# CITY OF ALBUQUERQUE

**Re: Risen Savior Catholic Parking Lot Improvements**  
**7810 Scotts PI NE**  
**Traffic Circulation Layout**  
Architect's Stamp 07-15-16 (D19D002)

Based upon the information provided in your submittal received 07-15-16, the above referenced plan cannot be approved for Building Permit until the following comments are addressed:

(D1) CLEAR SIGHT TRIANGLE EXHIBIT

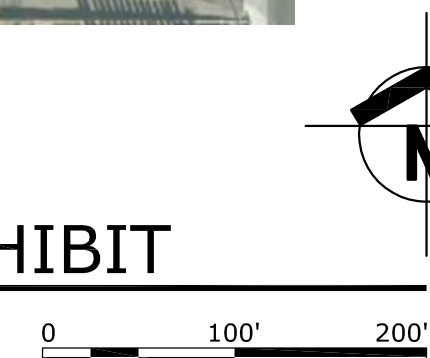
3. One-way vehicular paths require pavement directional sign at the point of egress. Please show detail and location of posted signs.
4. Please provide a clear sight triangle exhibit and add the following note to the clear sight triangle: "Landscaping and signage will not interfere with clear sight requirements. Therefore, signs, walls, trees, and shrubbery between 3 and 8 feet tall (as measured from the gutter pan) will not be acceptable in this area."

VECINITY MAP

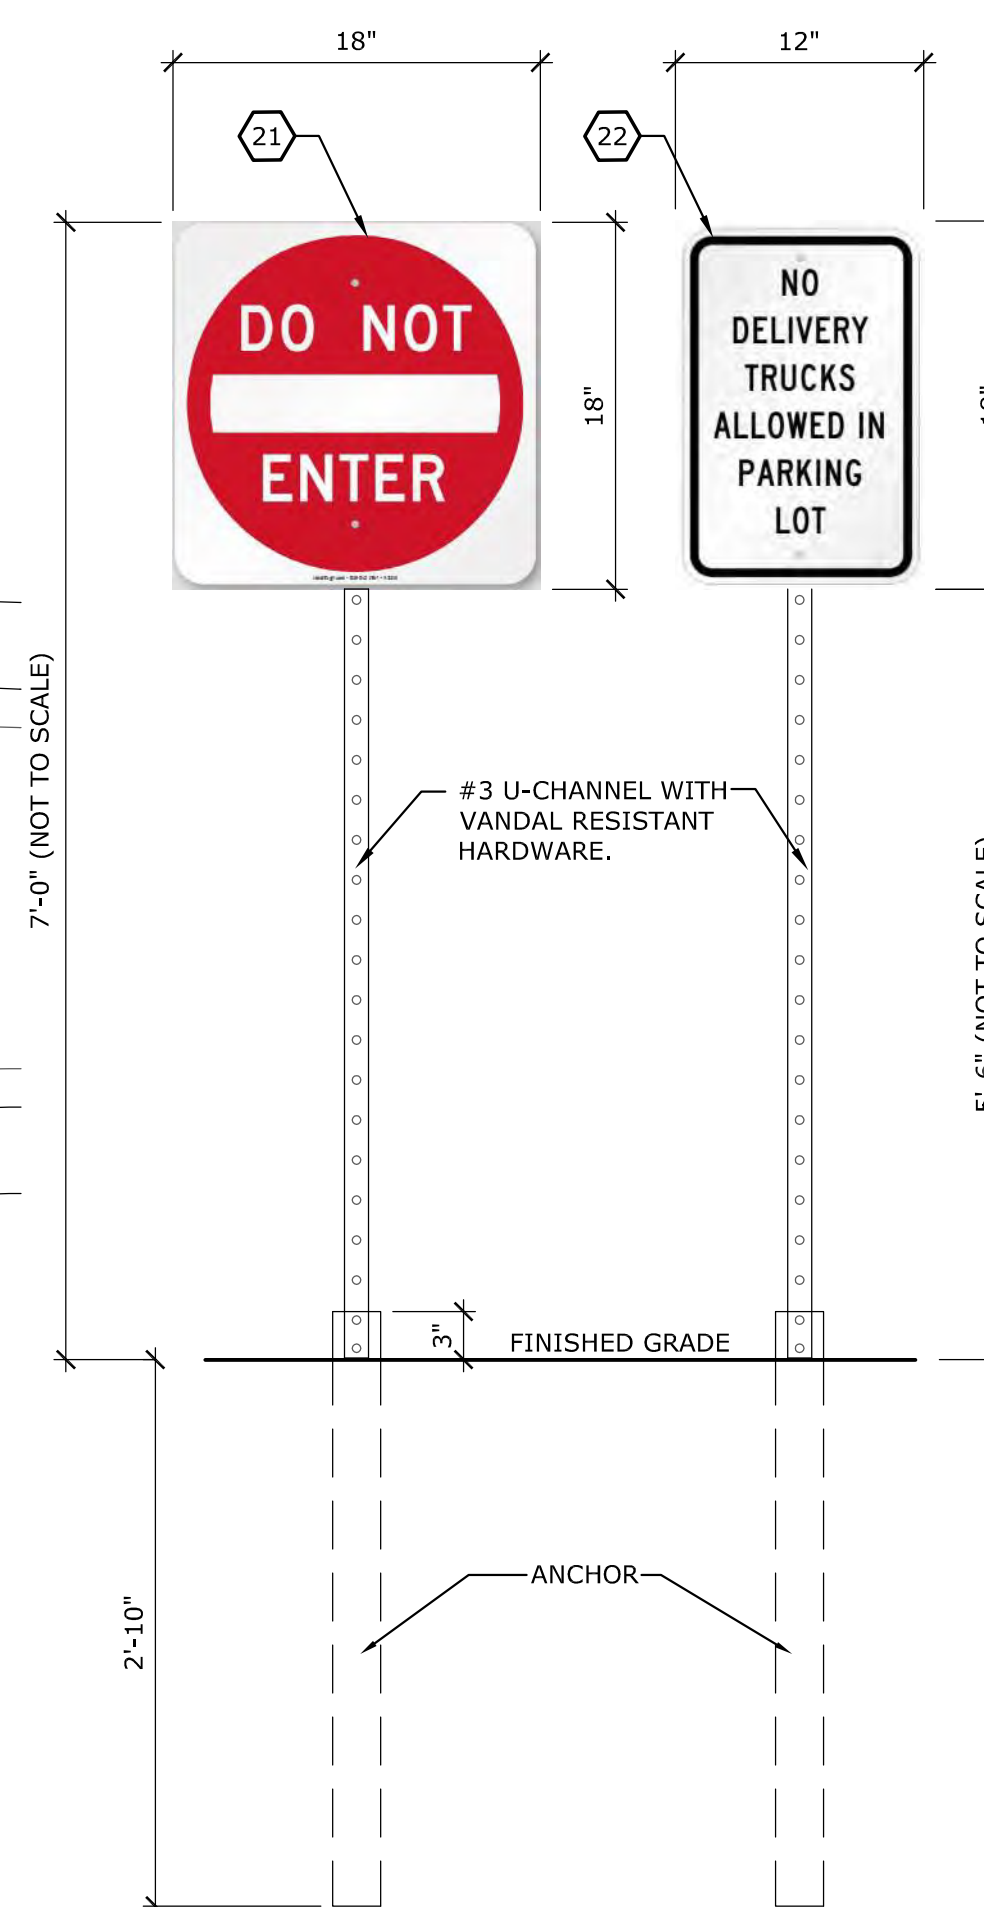
7. Clarify where the project is located. The vicinity map is confusing. Direction of North arrow is incorrect.
8. Please add a dimension at all the pinch points.(i.e. from the garage to the landscaping island.)

Ⓐ SITE PLAN - TCL (PLAN ROTATED 90 DGREES CW FROM TRUE NORTH)

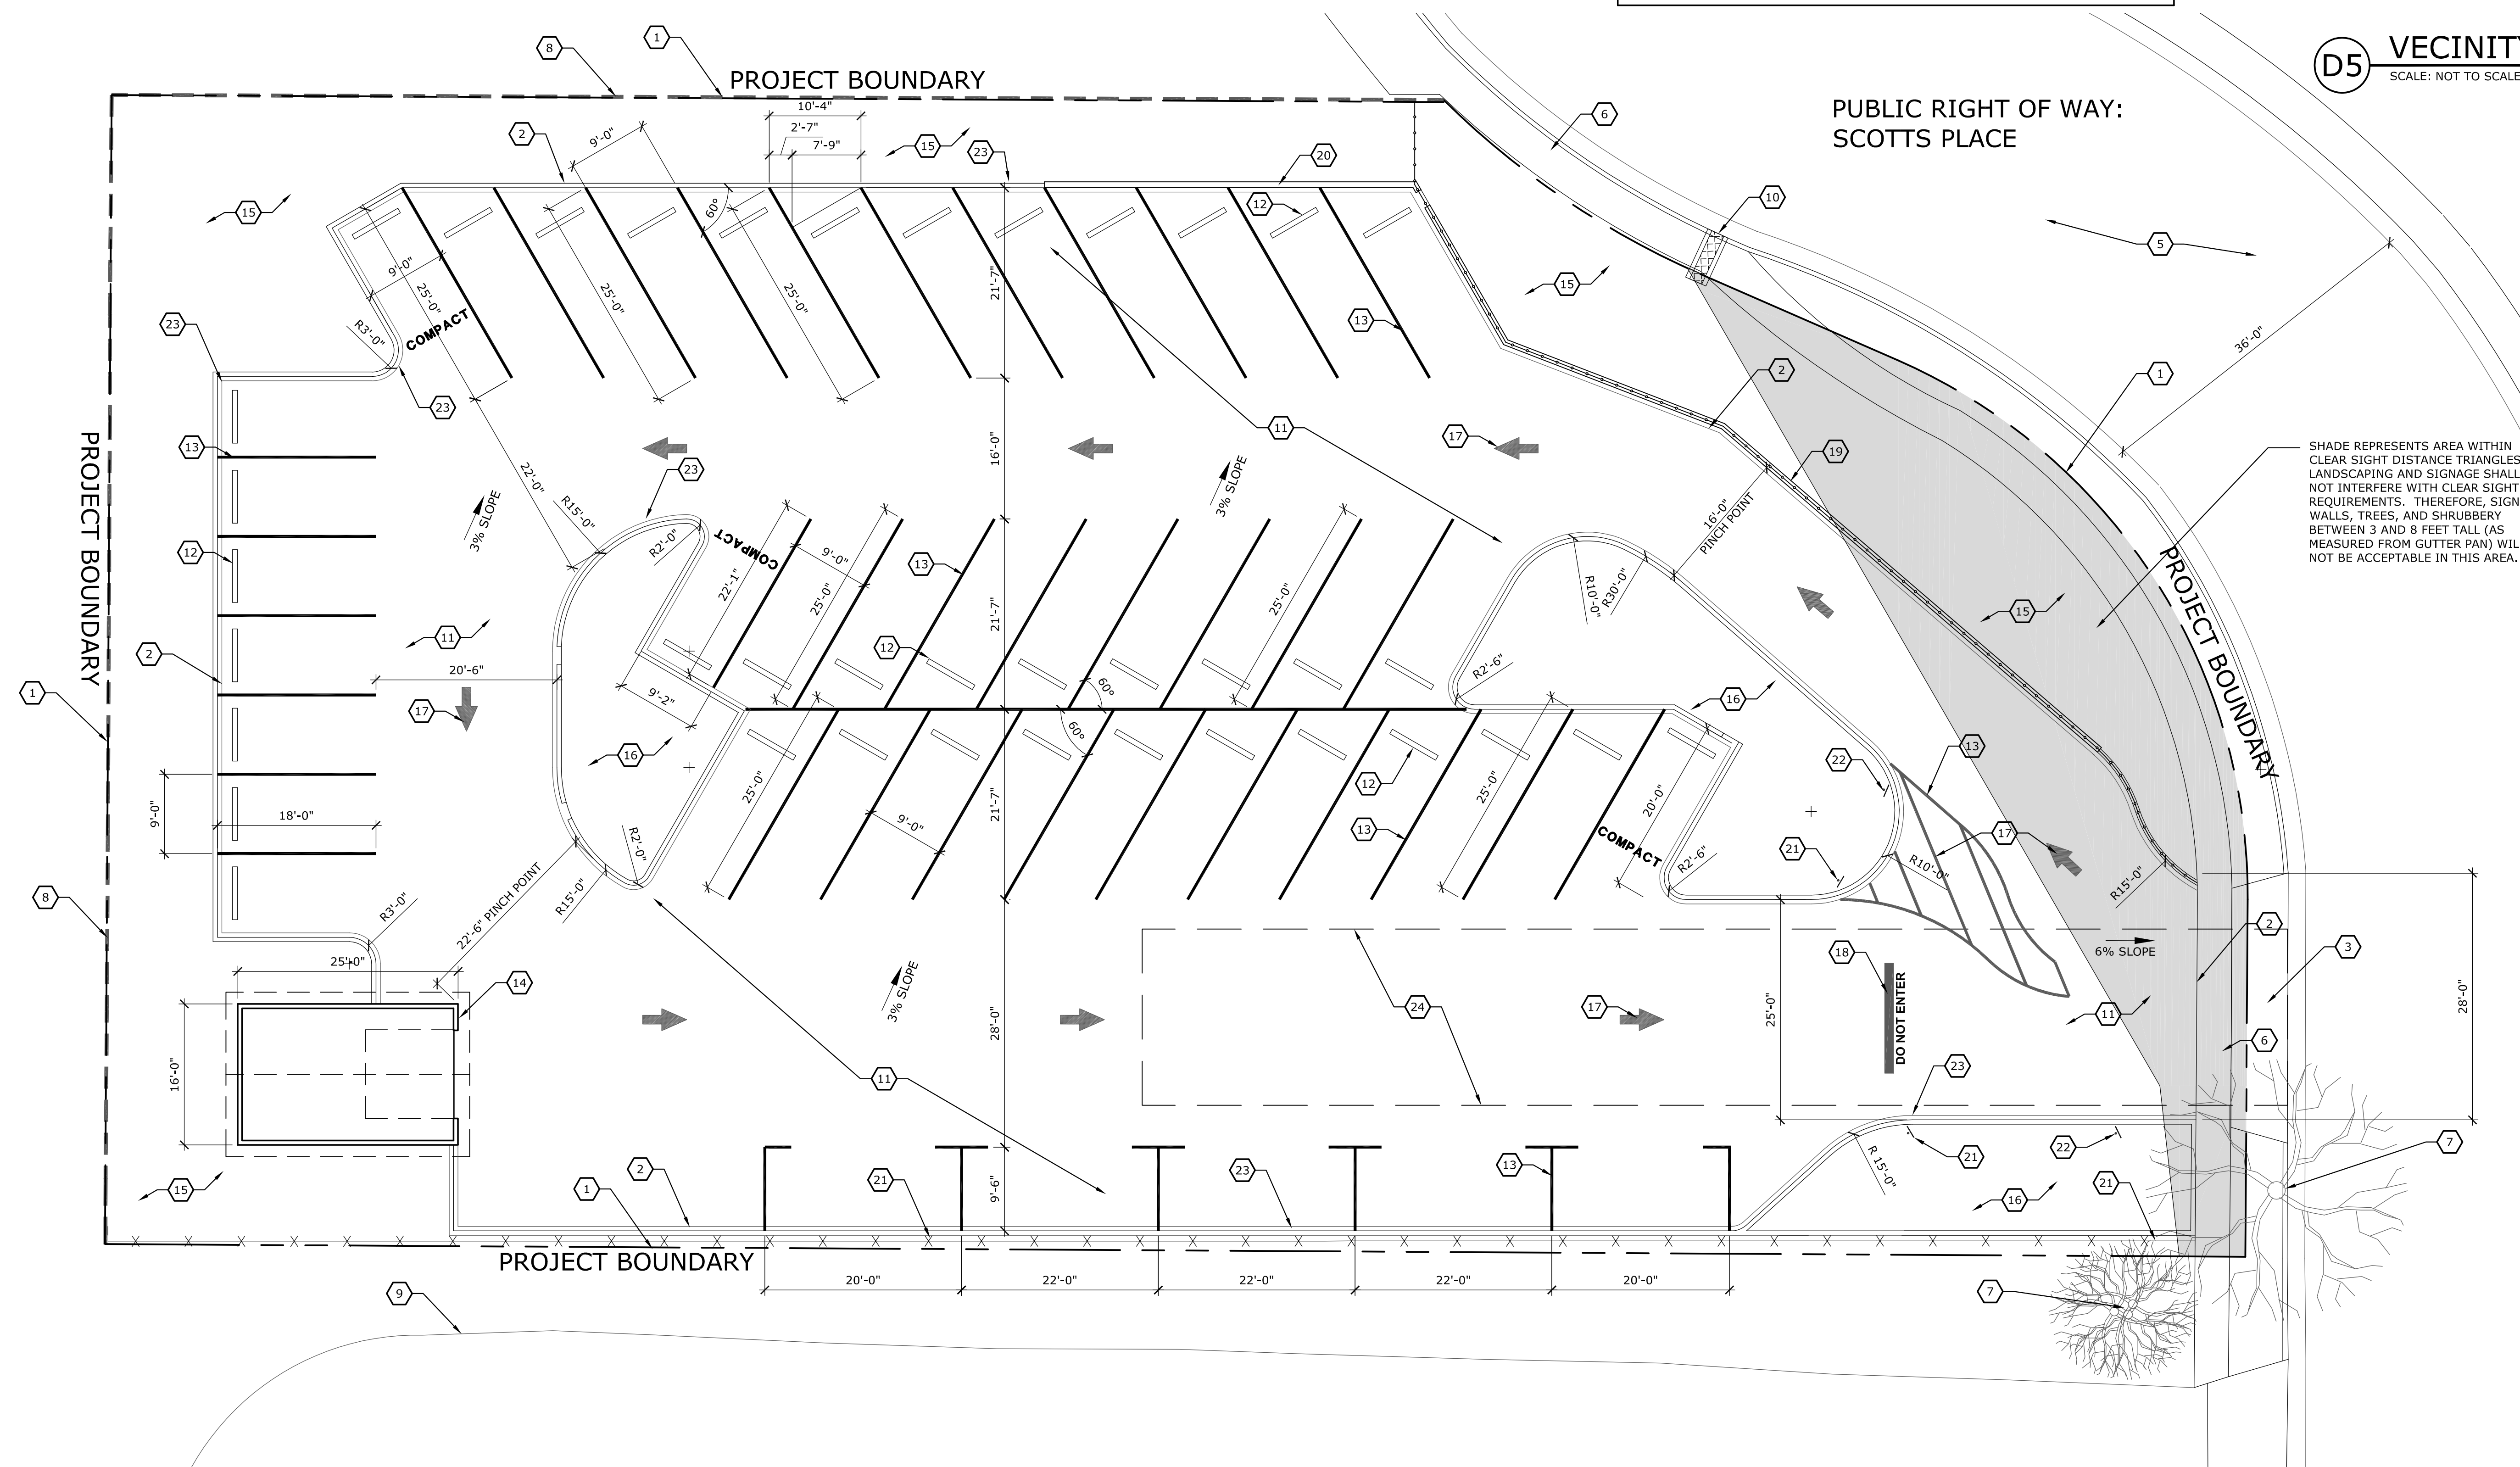
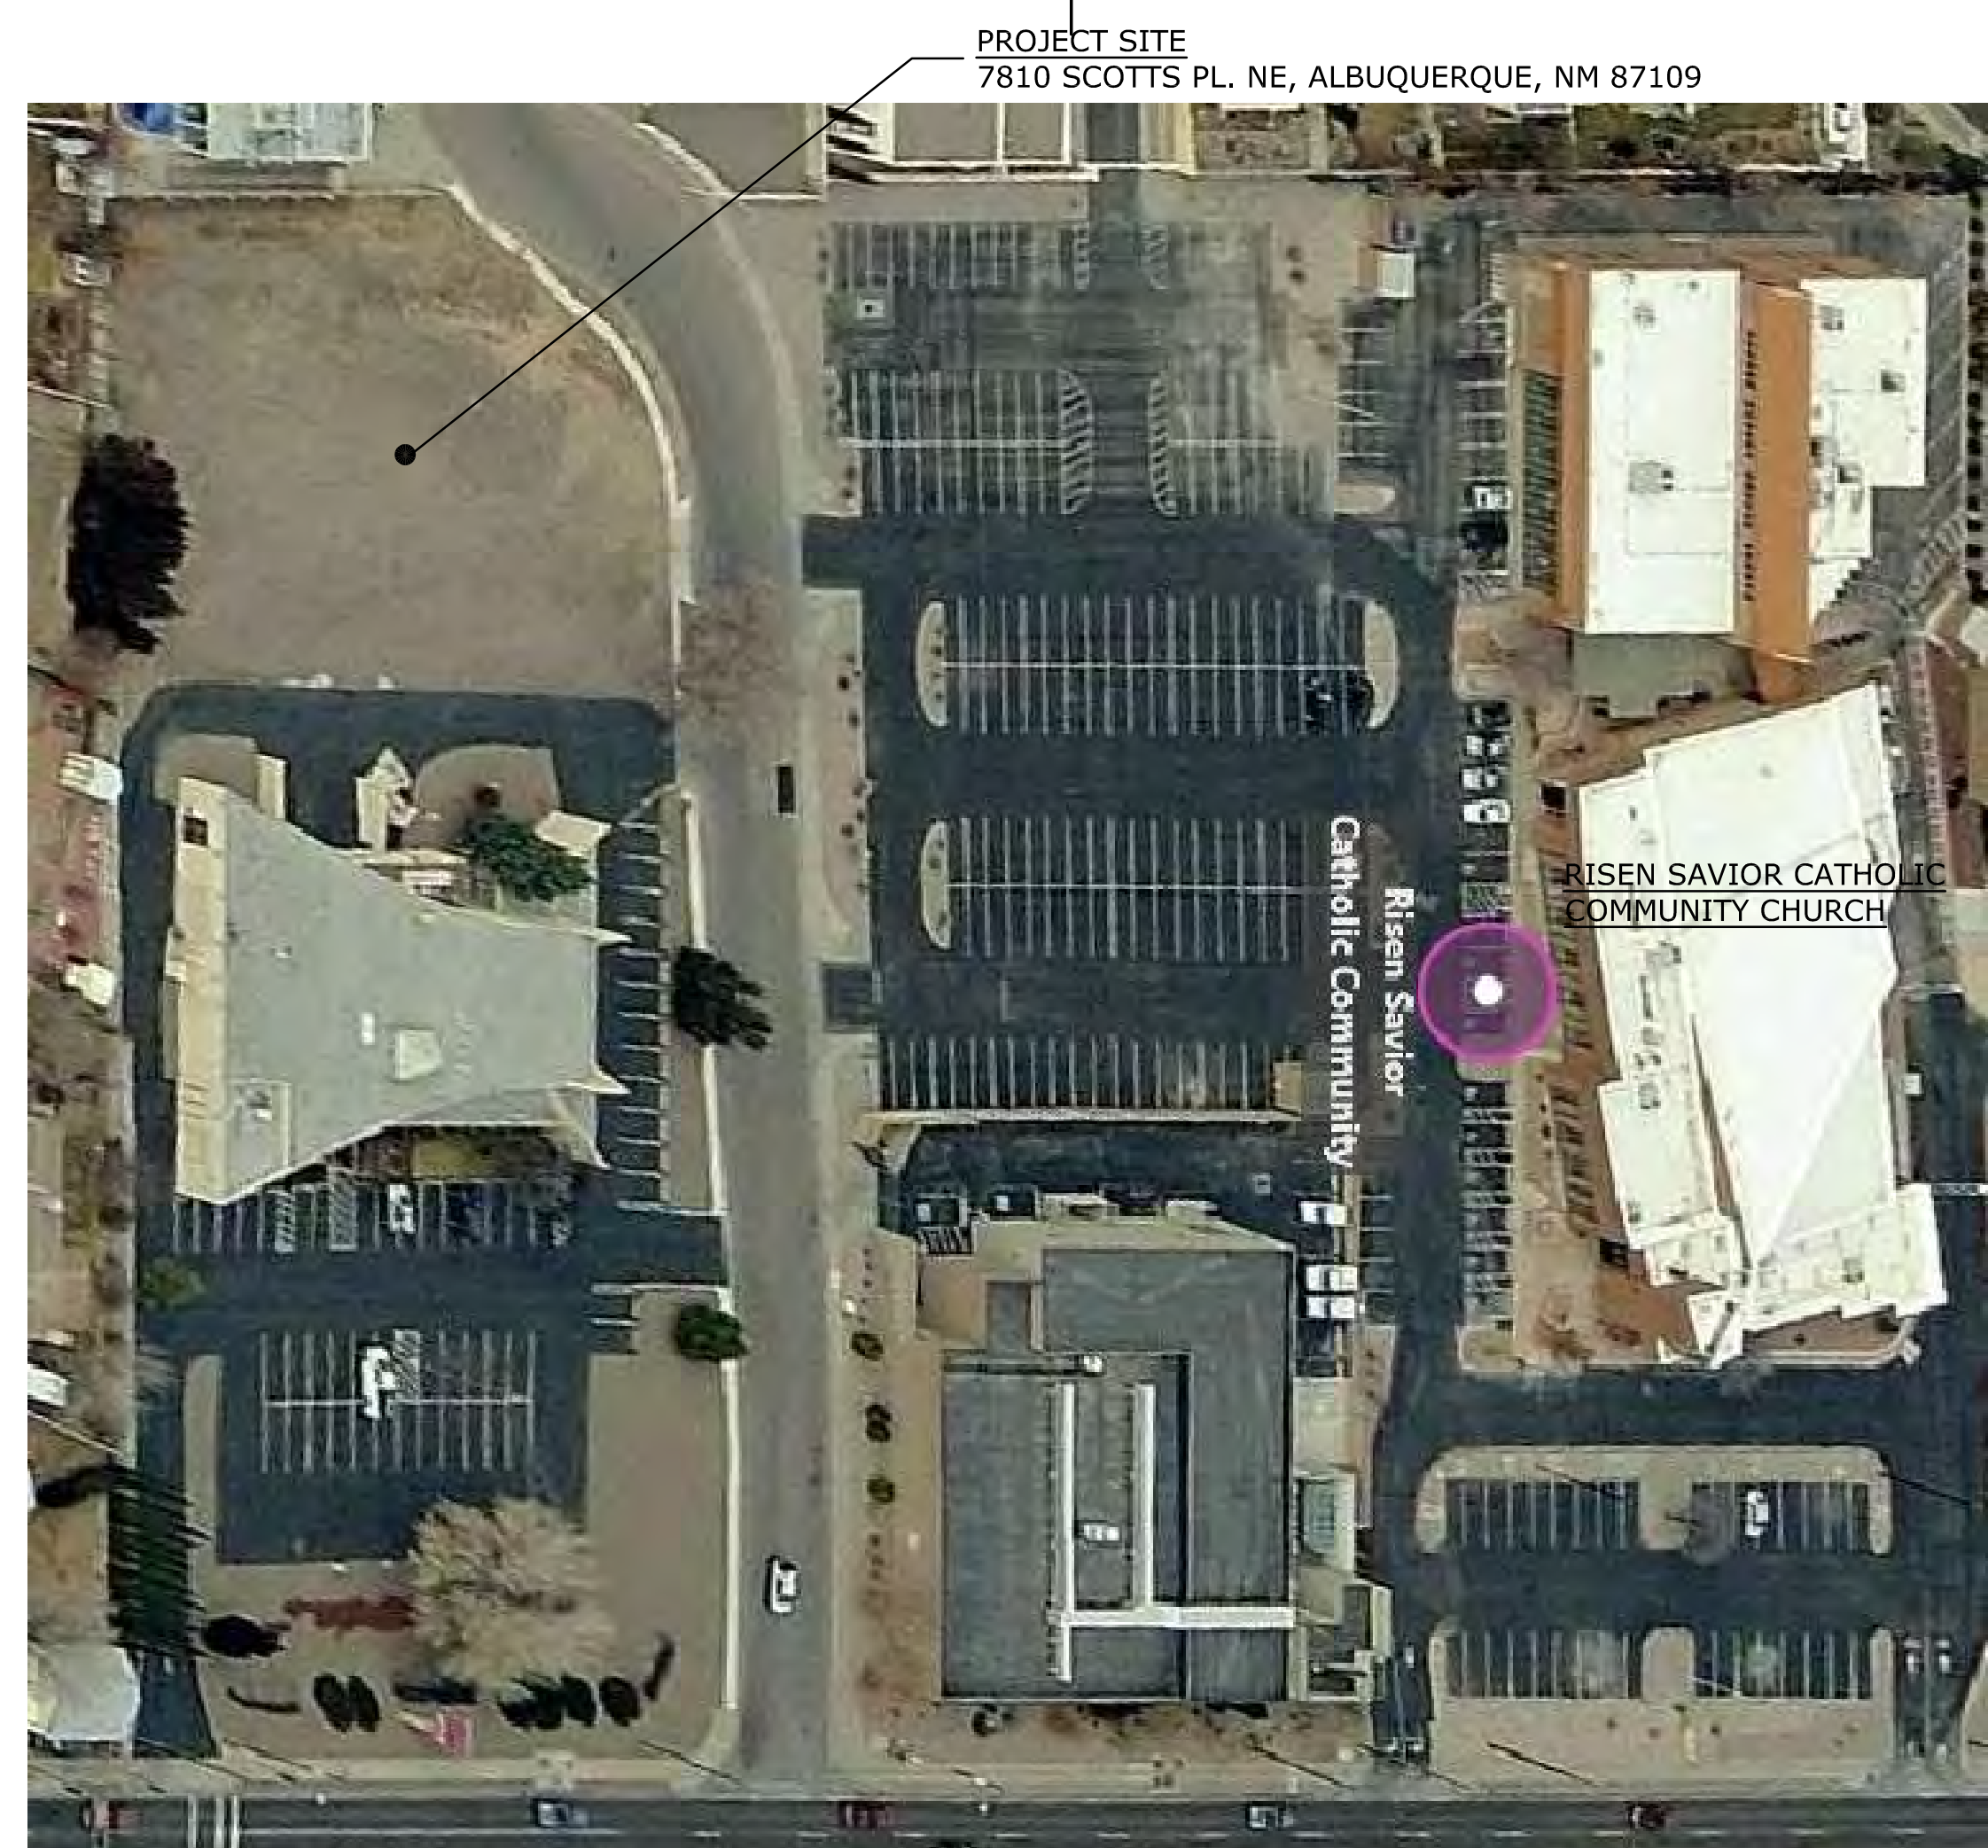
1. Please list the length for all existing and proposed parking spaces.
2. List radii for all curves shown; for passenger vehicles, the minimum end island radius is 15 ft. Landscape island radius for delivery trucks, fire trucks, etc. is 25 ft. or larger.

5. Please specify the City Standard Drawing Number when applicable
6. It appears that a portion of the public sidewalk is in the private property. Please provide a public pedestrian access easement.

9. Please add a note on the plan stating "All improvements located in the Right of Way must be included on the work order."
10. Please add a note stating "All broken or cracked sidewalk must be replaced with sidewalk and curb & gutter." A build note must be provided referring to the appropriate City Standard drawing.
